FINAL DRAINAGE REPORT

PPR 234

Schubert Ranch Sand Resource Pit

## STAGE 1 OF 6 - GRADING AND EROSION CONTROL PLANS EA#1881

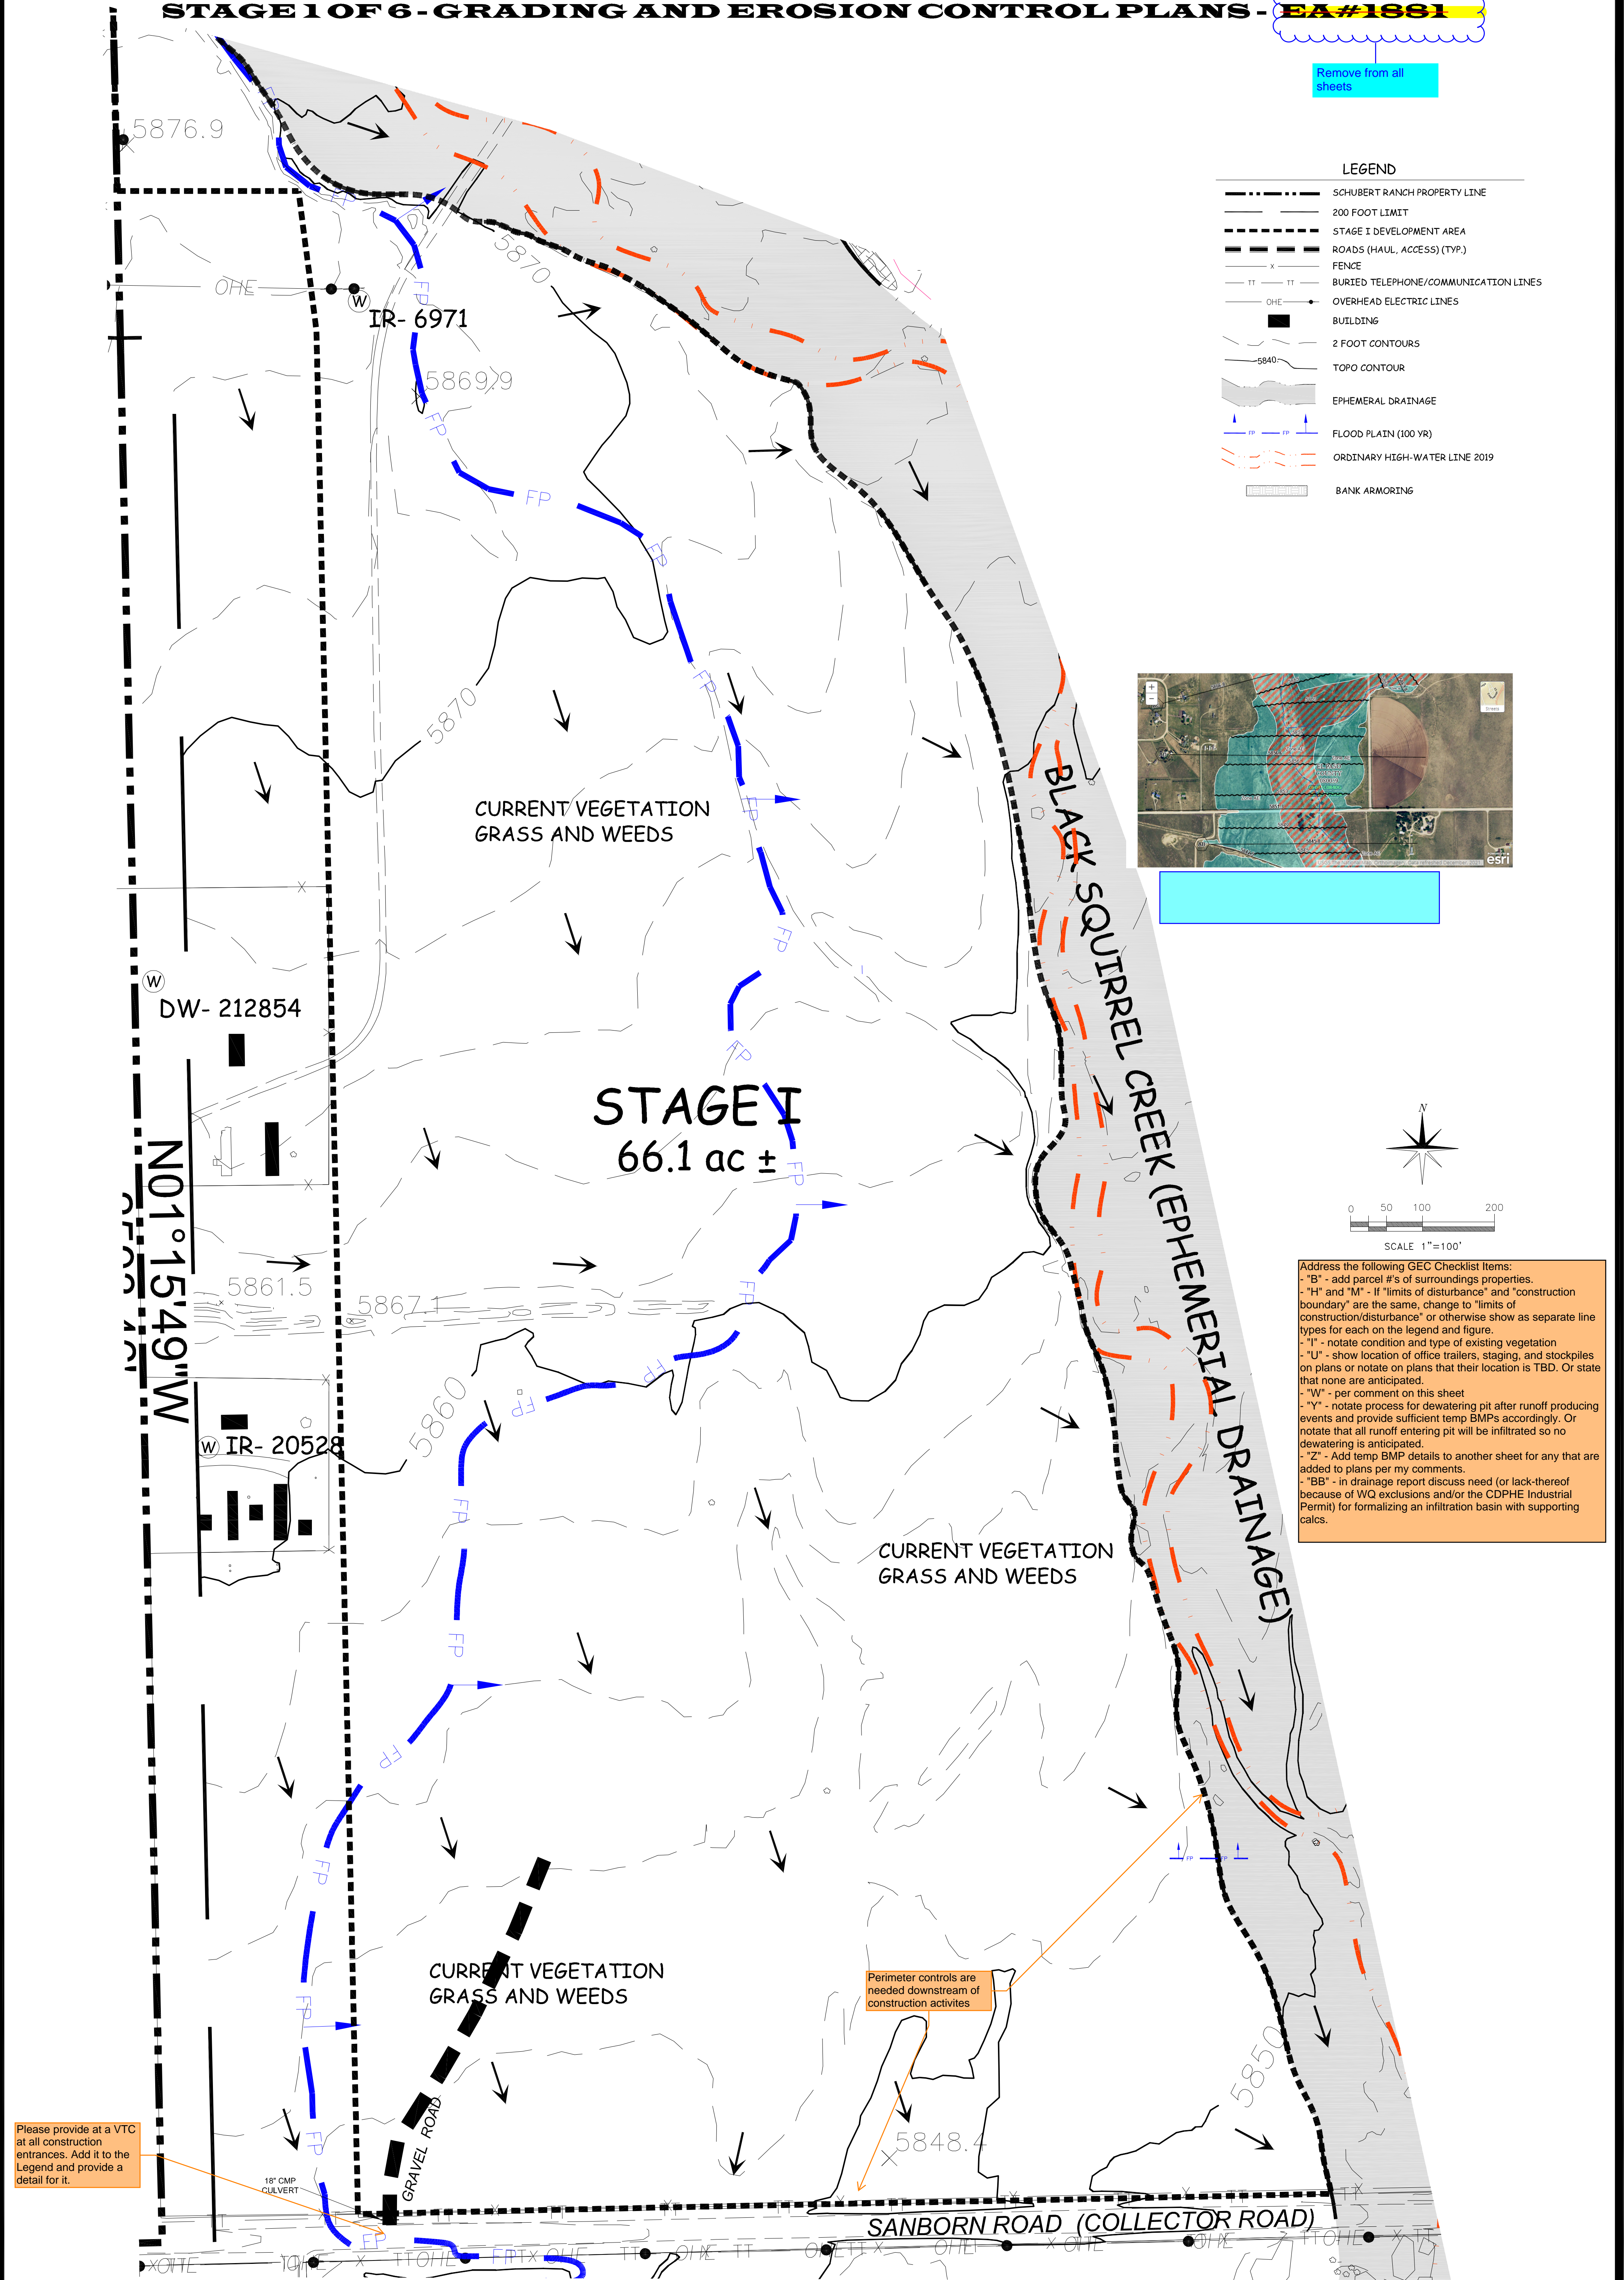
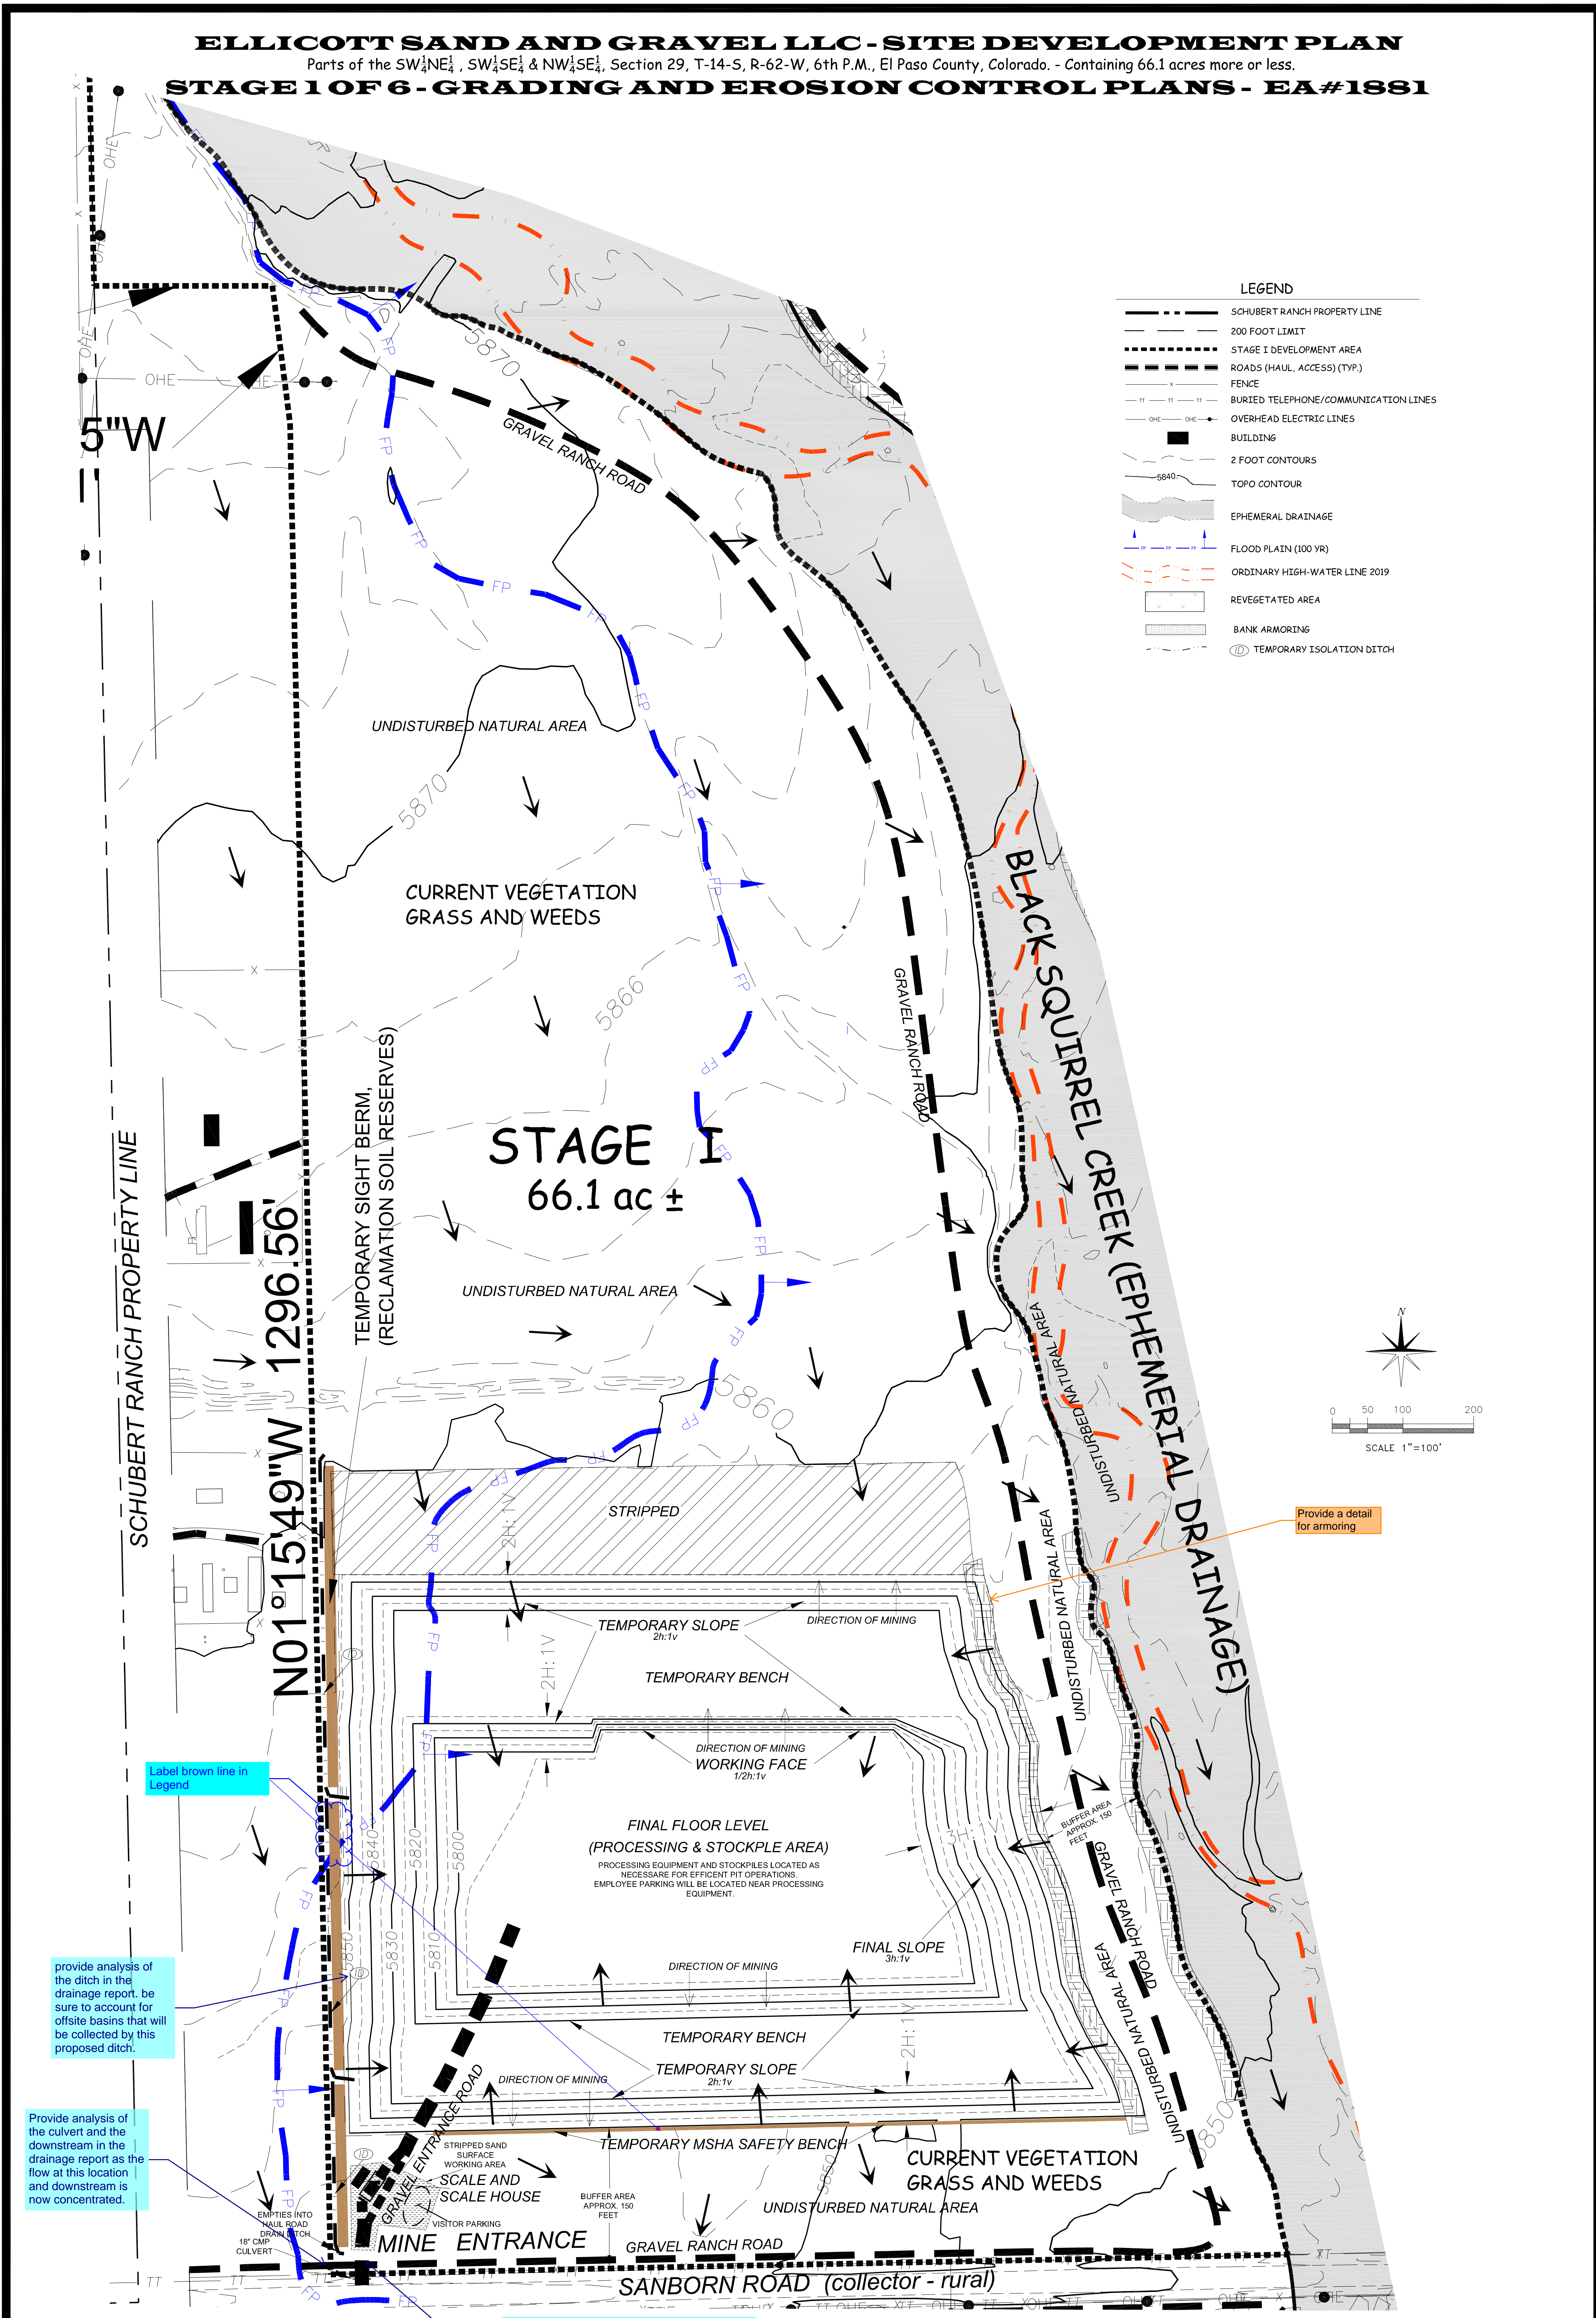
Discuss offsite basin from the west
Update drainage maps with on and offsite flows included in discussion.

discuss any flows from the western residential subdivision that drain to this site. Discuss the western berm that is proposed in the GEC plan and analyze the redirection of flow.

Show location of SF on GEC Plans and/or add them as "TBD" or "as needed" to notes on GEC Plan.
